RE: Trent Short Plat, File #SP-07-26

Kittitas County Community Development Services has determined that the Trent Short Plat is a complete application and hereby grants **conditional** preliminary approval subject to the following conditions:

TRENT SHORT PLAT - NO. SP-07-26
 LOCATED IN SECTION 9, T-21 NORTH, R-14 EAST, W.M.
 KITTITAS COUNTY, WASHINGTON

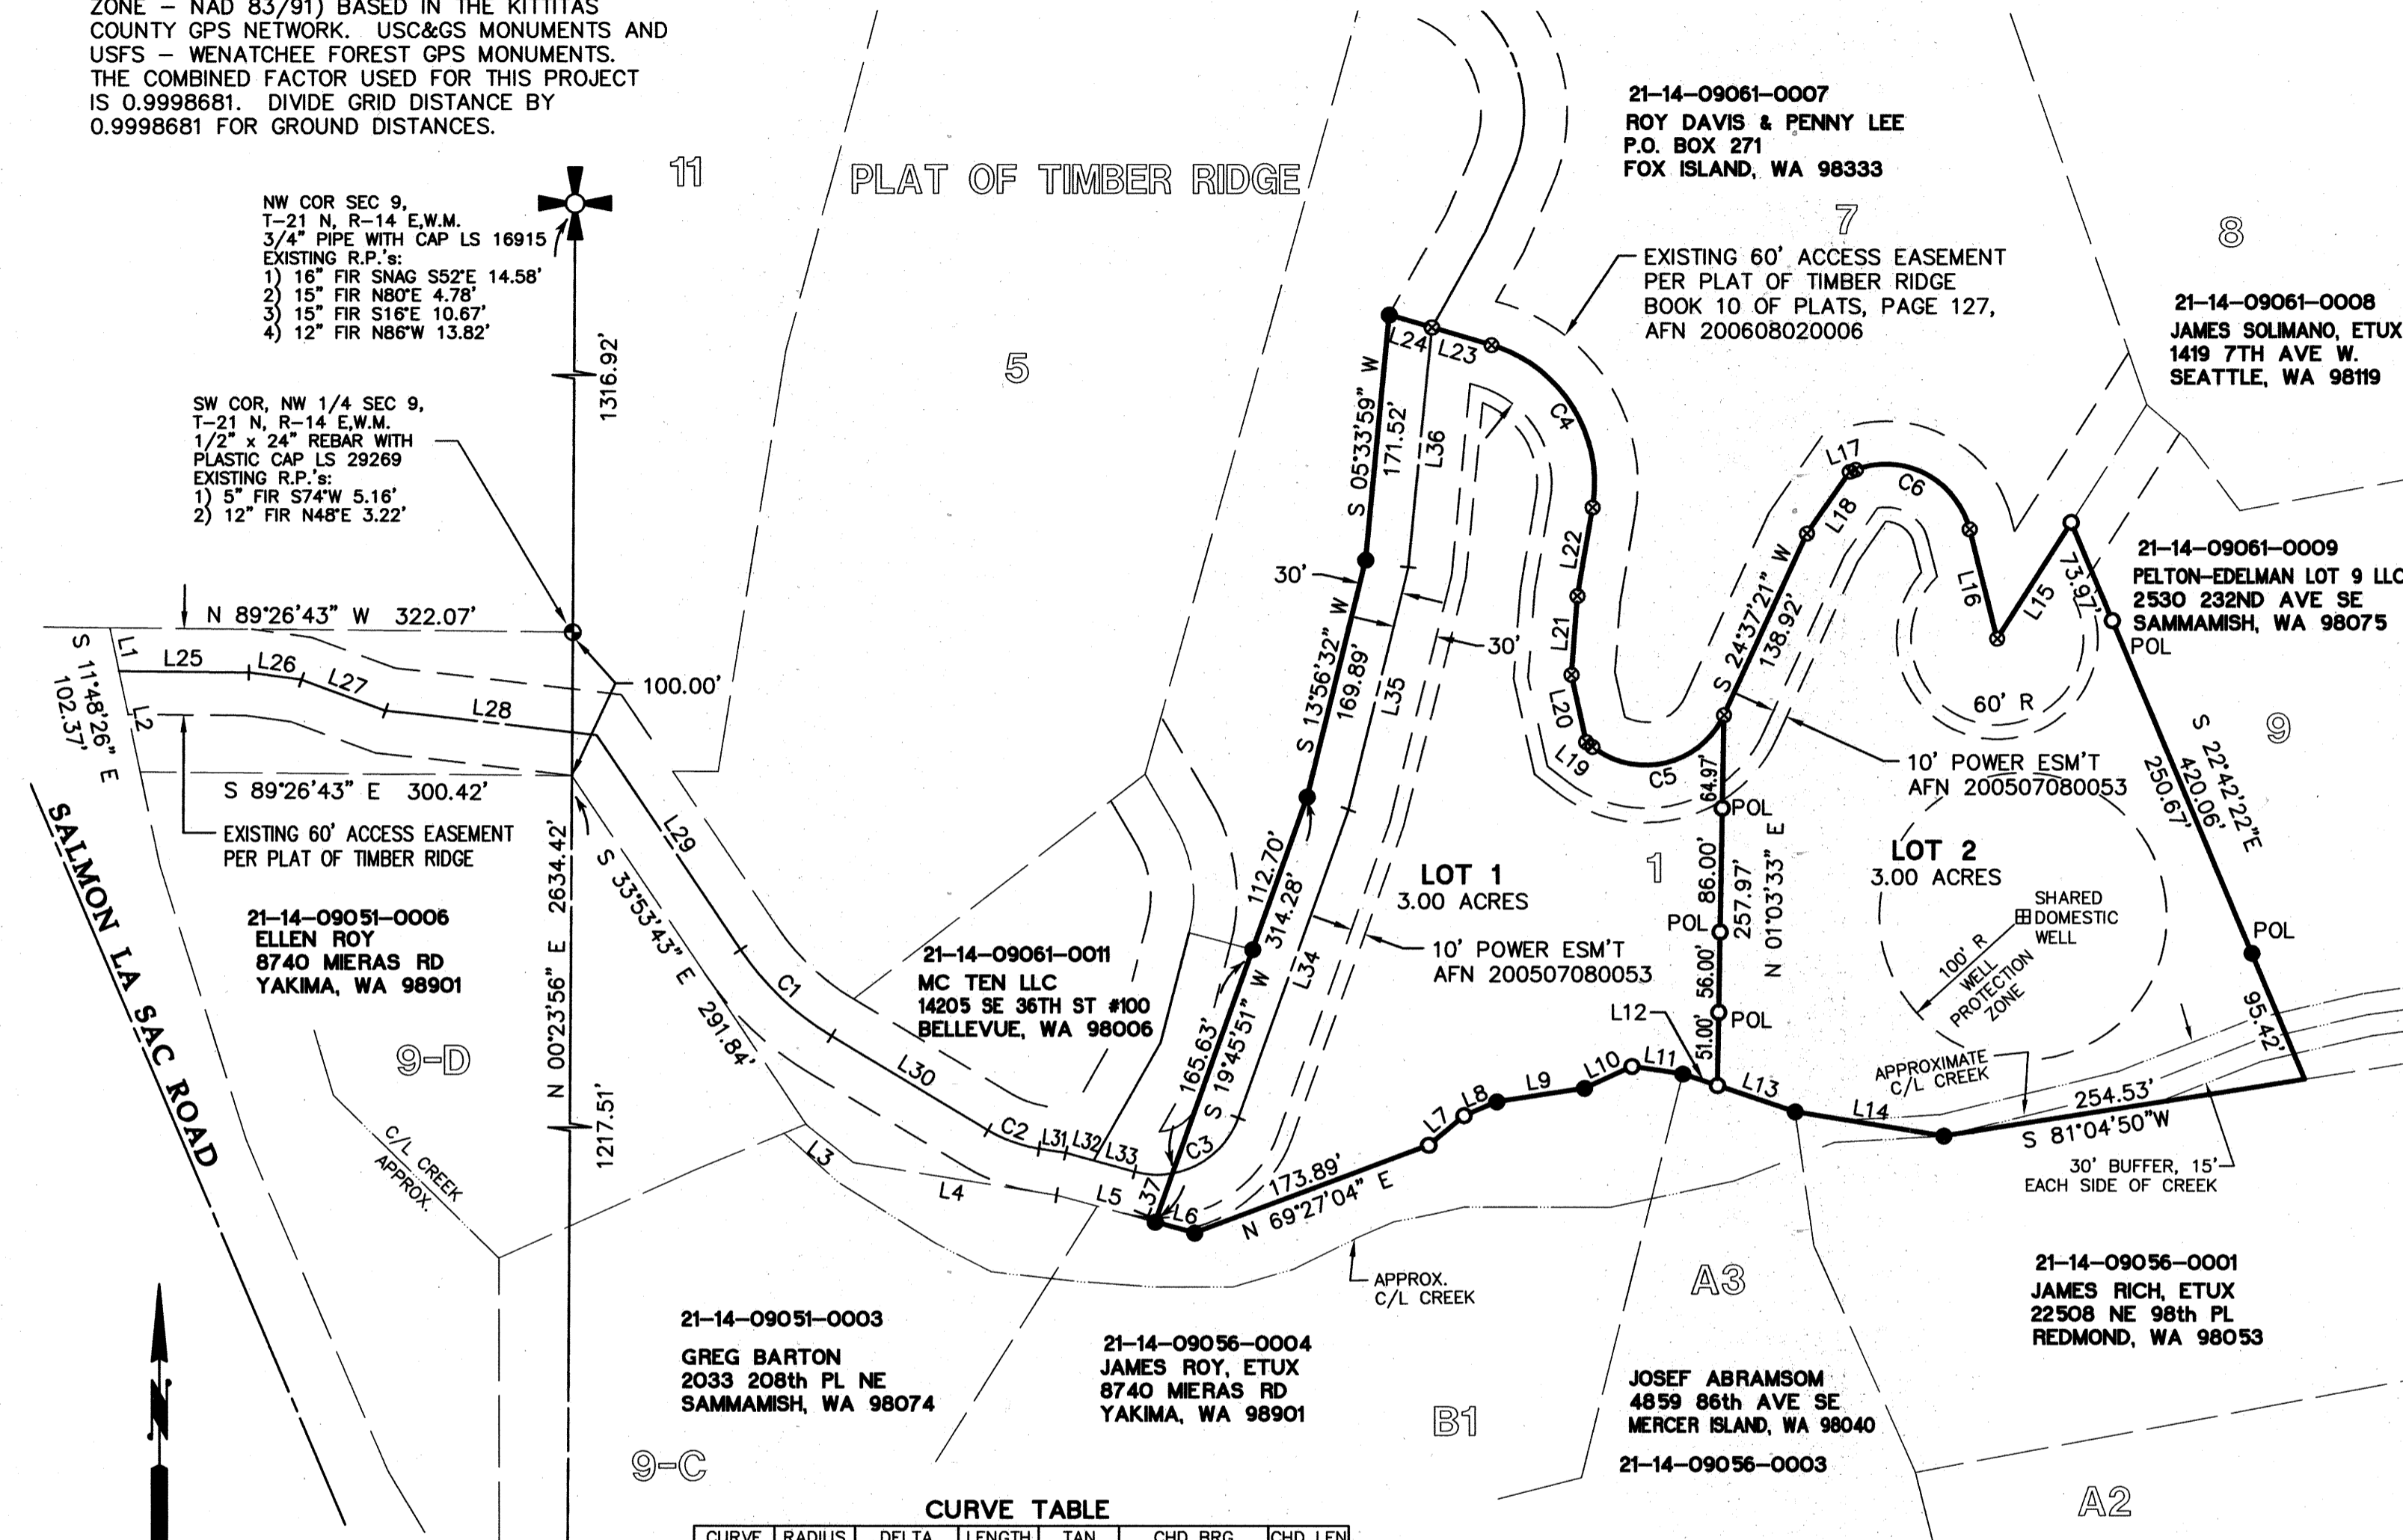
1. A statement regarding drainage improvements shall be reflected on the final mylars.
2. A vicinity map showing the boundary lines of all adjacent subdivisions shall be reflected on the final mylars.

3. The name and address of the property owner(s) shall be on the short plat mylars.
4. The Seal of the registered land surveyor who made, or under whose supervision was made, a survey of the short plat along with signature and expiration date.

5. The approval signature box for the signature of the Kittitas County Engineer will be addressed 'Kittitas County Department of Public Works'.
6. The name and address of the owner shall be on the final mylar.

7. Required monuments shall be shown together with a legend of monuments on the face of each plat sheet. Ordinance 2005-31, 2005.
8. The following plat notes need to be included in the final mylars:

- At the time of preliminary plat approval the parcels contained within the plat are not located within a fire district. Any construction within this plat shall be subject to the International Fire Code and International Urban Wild-Land Interface Code, and additional special building and site development requirements shall be applied.

- All non-community wells must be placed a minimum of 50 feet from property lines. KCC 17A.08.020.
9. All Kittitas County road standards must be met. Attached you will find comments from Kittitas County Public Works. Please contact Randy Carbery at 962-7523 regarding all road standards and access questions.
